DRB Application No.: 04DRB-00527-~~(P&E)~~^{SBP} Project # 1003370
 Project Name: ALAMEDA BUSINESS PARK
 Agent: Schlegel Lewis Architects Phone No.: 247-1529

**CITY OF ALBUQUERQUE
PLANNING DEPARTMENT
Development Review Board
April 14, 2004
Comments**

RE: Tract 28, Alameda Business Park/SPBP

Elevations
 PROJECT SHEET
 0406 **SDP-5**
 OF 5

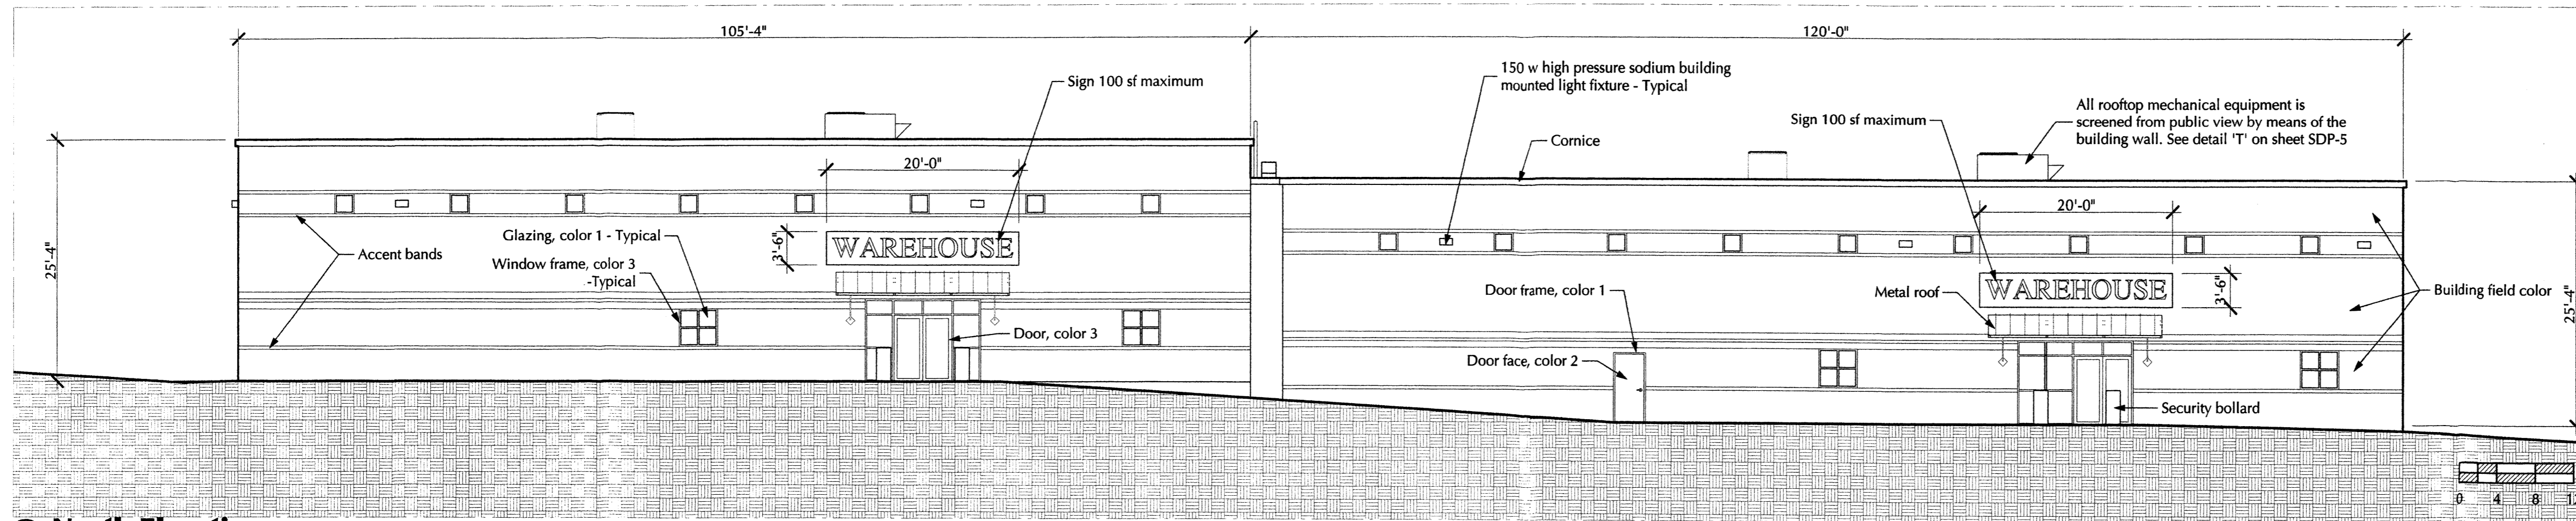
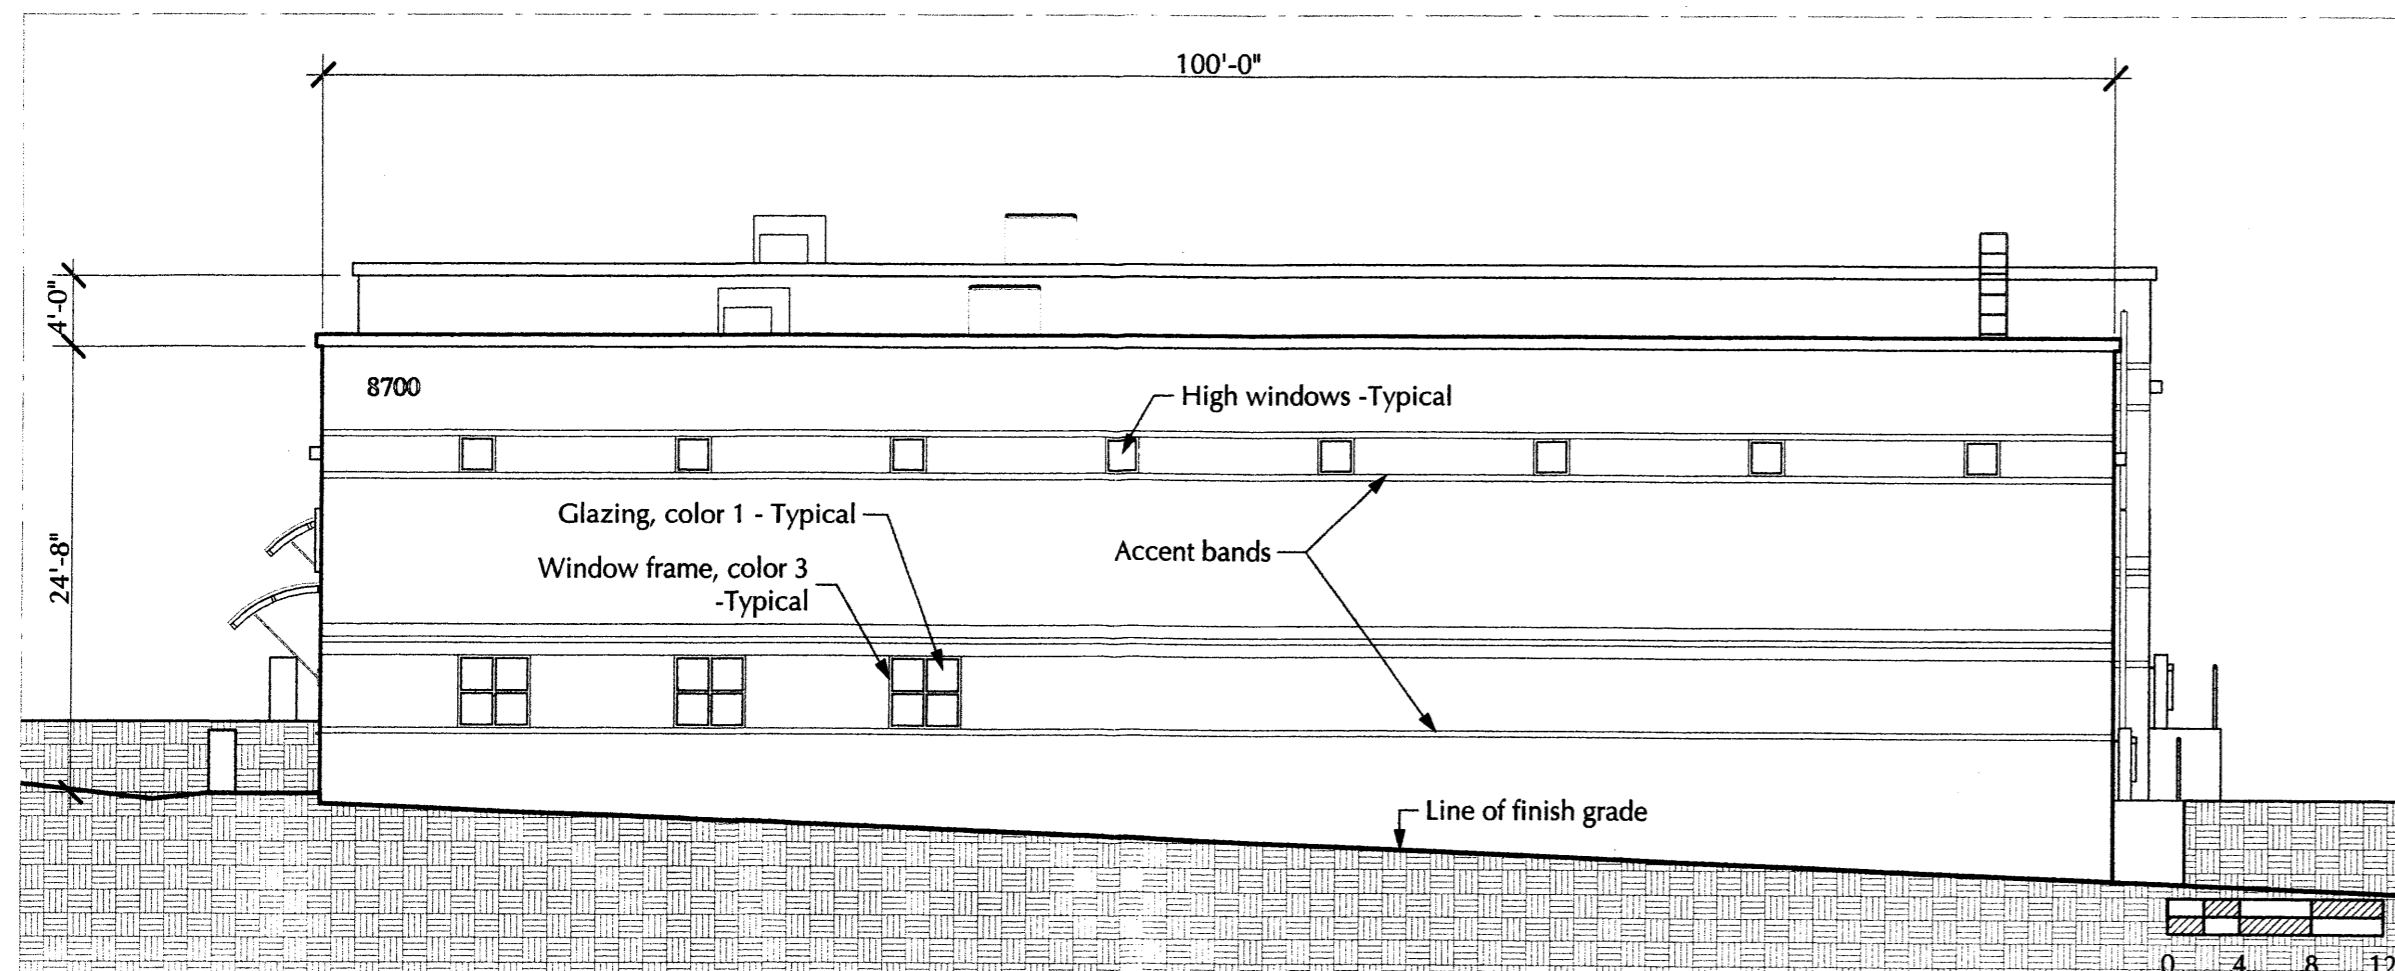
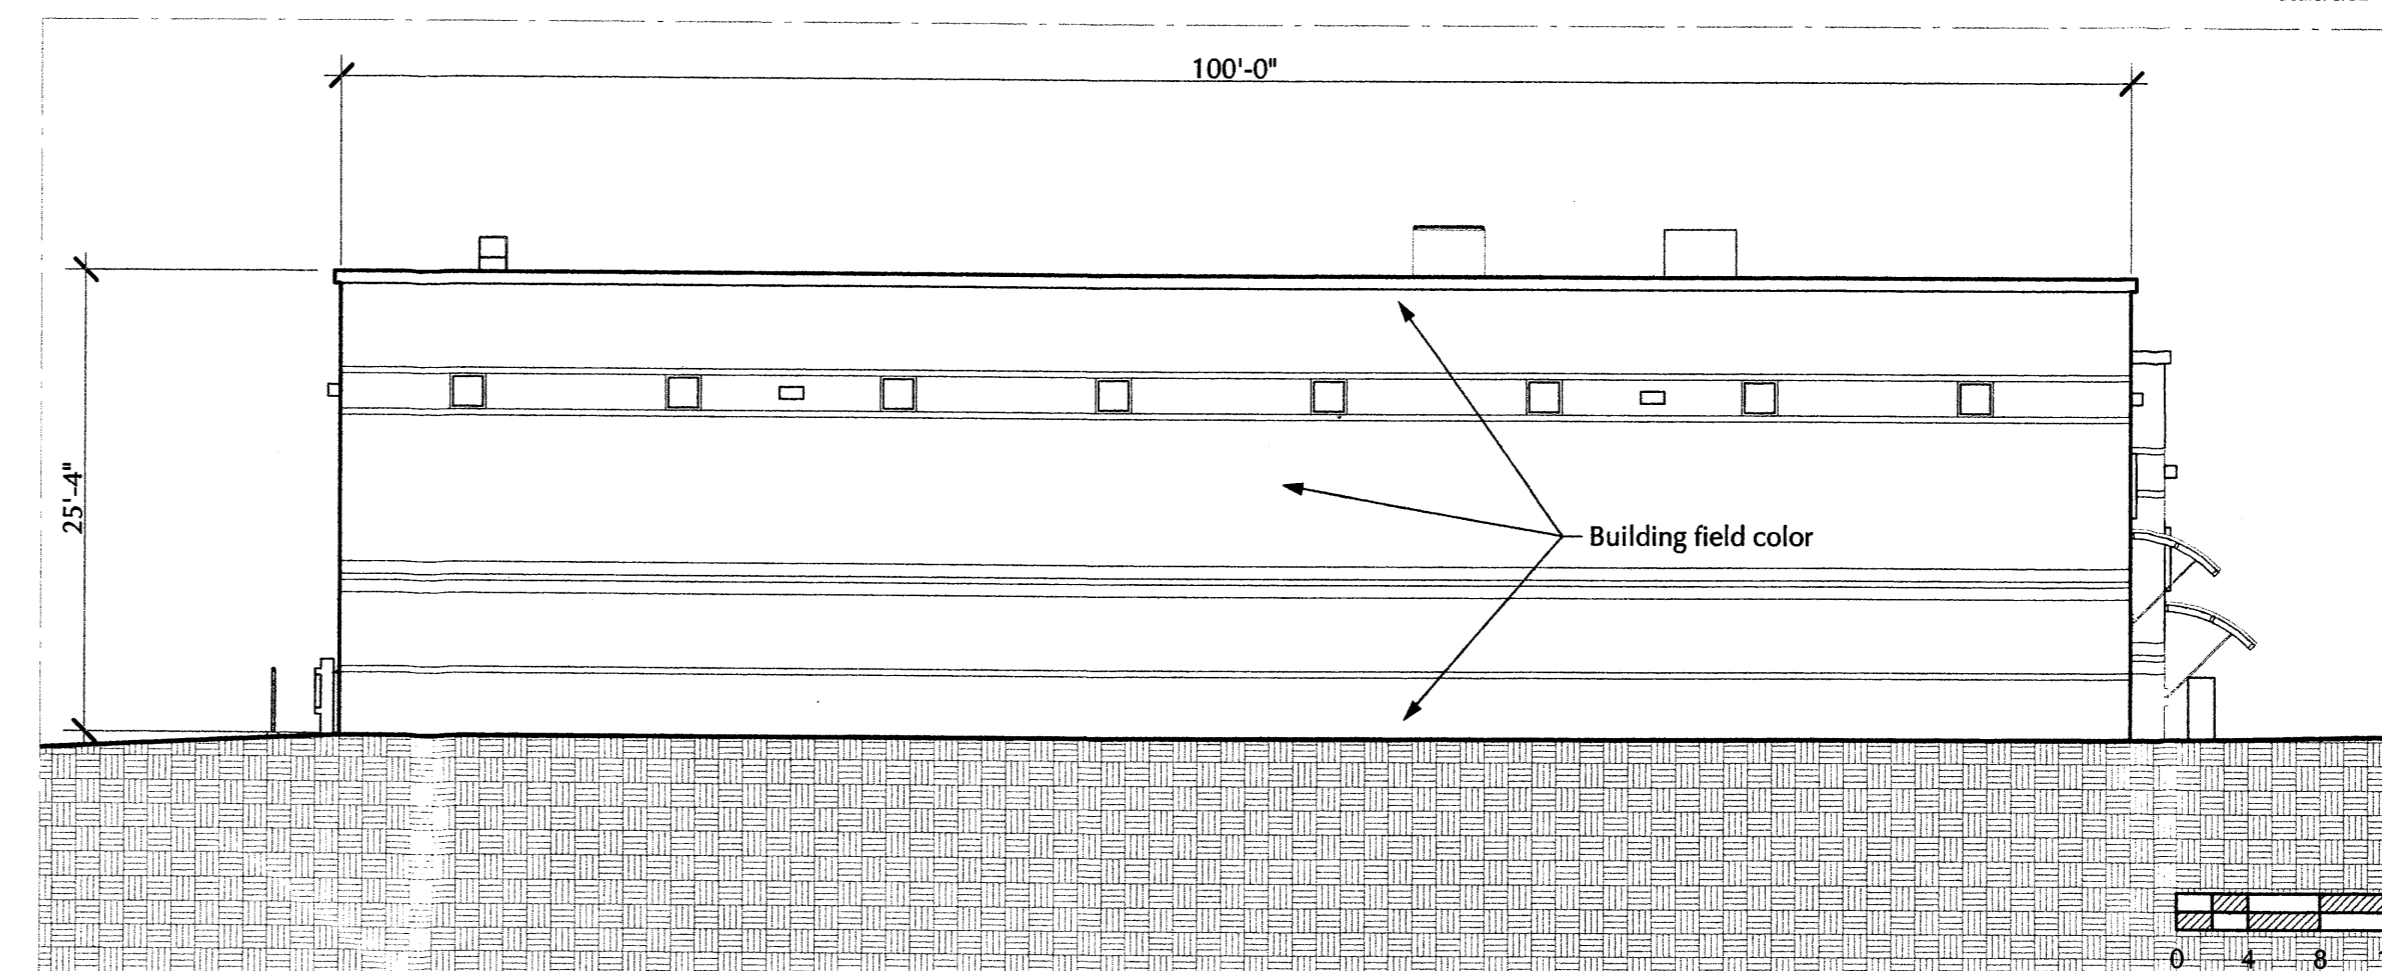
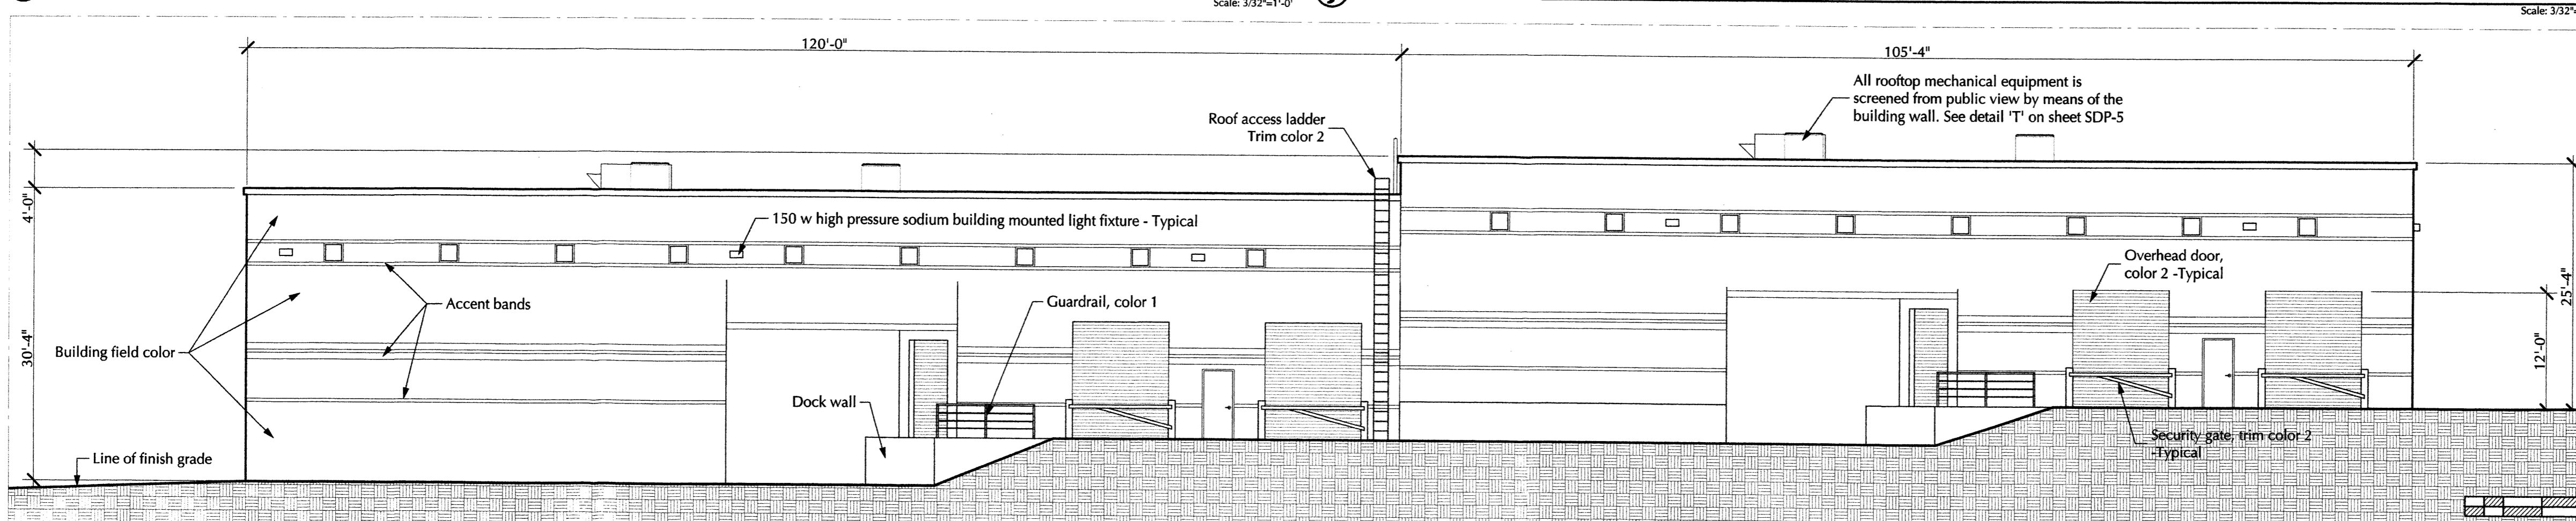
- ✓ 4. The parking space calculations, what's required and what's provided, are required on the site plan sheet.
- ✓ 5. Landscape Plan. Please remove all junipers as they are a high allergen plant. There are several misspelled words on this sheet. The Alameda Business Park Master Plan requires a 10' landscape buffer as a front yard setback. This is lacking.
- ✓ 6. Roof Mounted Equipment. The Alameda Business Park Master Plan states: "Roof equipment screens are to be at least as high as the equipment." The current elevations sheet detail does not conform to that requirement.

7. Building Mounted Sign. The Master Plan states that this sign shall not exceed 3'6" in dimensional height of any portion of the sign. This note should be placed on the elevations sheet where the building mounted sign appears.

- ✓ 8. Materials of windows, doors & framing are required on the elevations sheet.
- ✓ 9. Both signs must have dimensions and square footage as well as materials & colors.
